**CITY OF ALBUQUERQUE
PLANNING DEPARTMENT
Development Review Board
June 30, 2004 Comments**

ITEM # 12

PROJECT # 1003031 APPLICATION # 04-00980

RE: El Rancho Grande, Unit 14/final plat

Drawn By:	RJA	Date:	05-17-04
Checked By:	TA	Drawing Name:	04008PLT.DWG
Job No.:	04-008	Sheet:	1 of 4

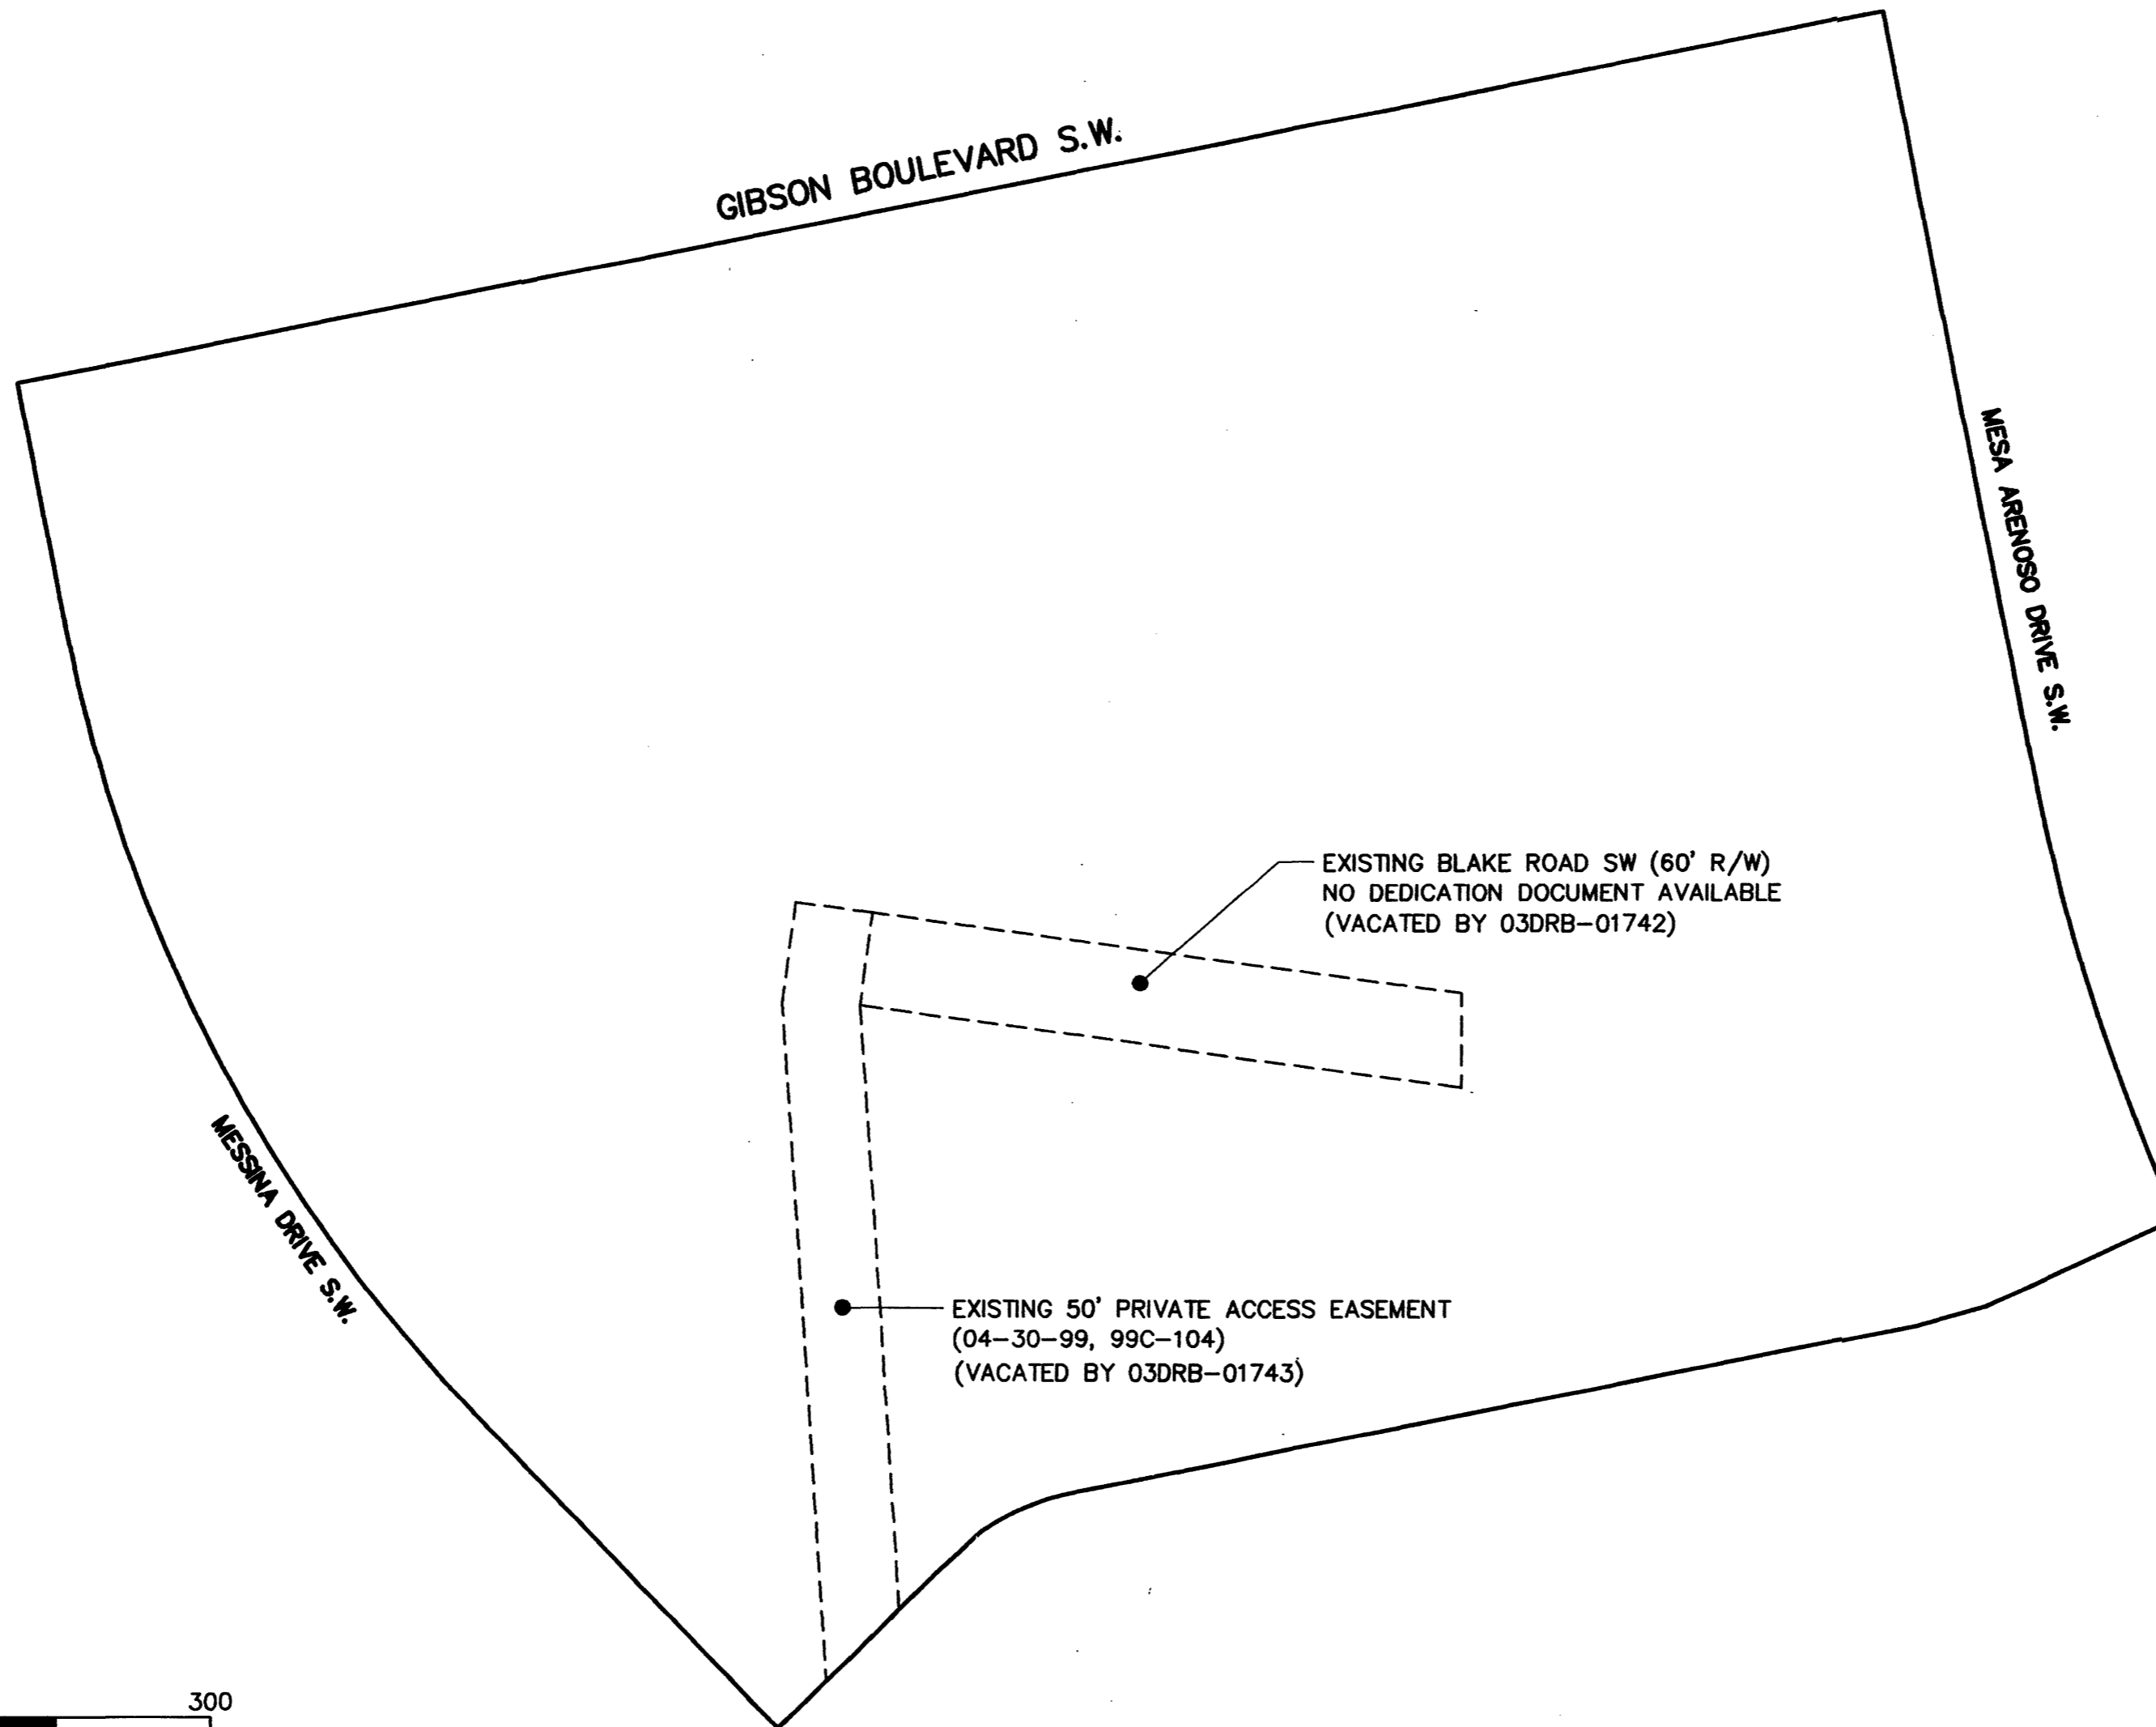
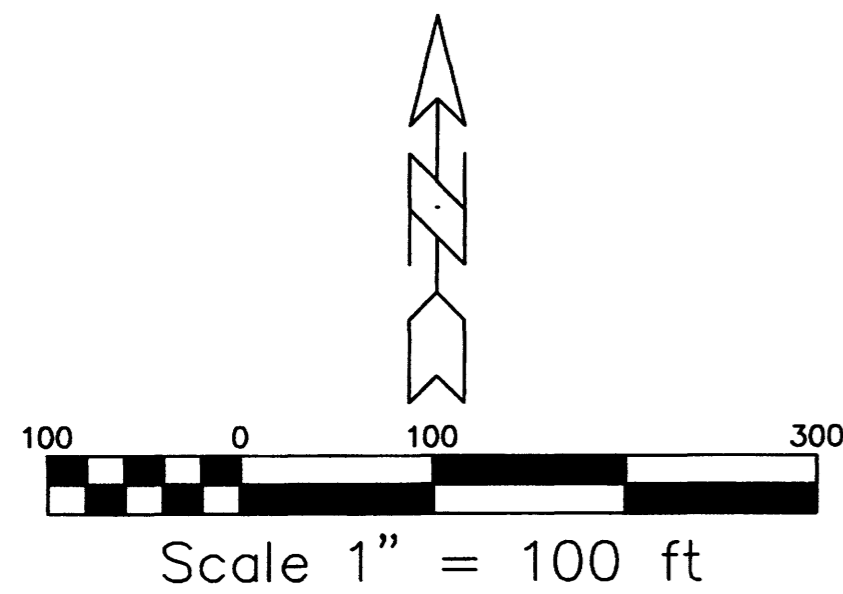
The current zoning should be listed under Subdivision Data on the plat.

This language is missing from the final plat. It should be above the owner's signature.

“Said owners warrant that they hold among them complete & indefeasible title in fee simple to the land subdivided.” OR if single owner: “Said owner warrants that he/she holds complete & indefeasible title in fee simple to the land subdivided.”
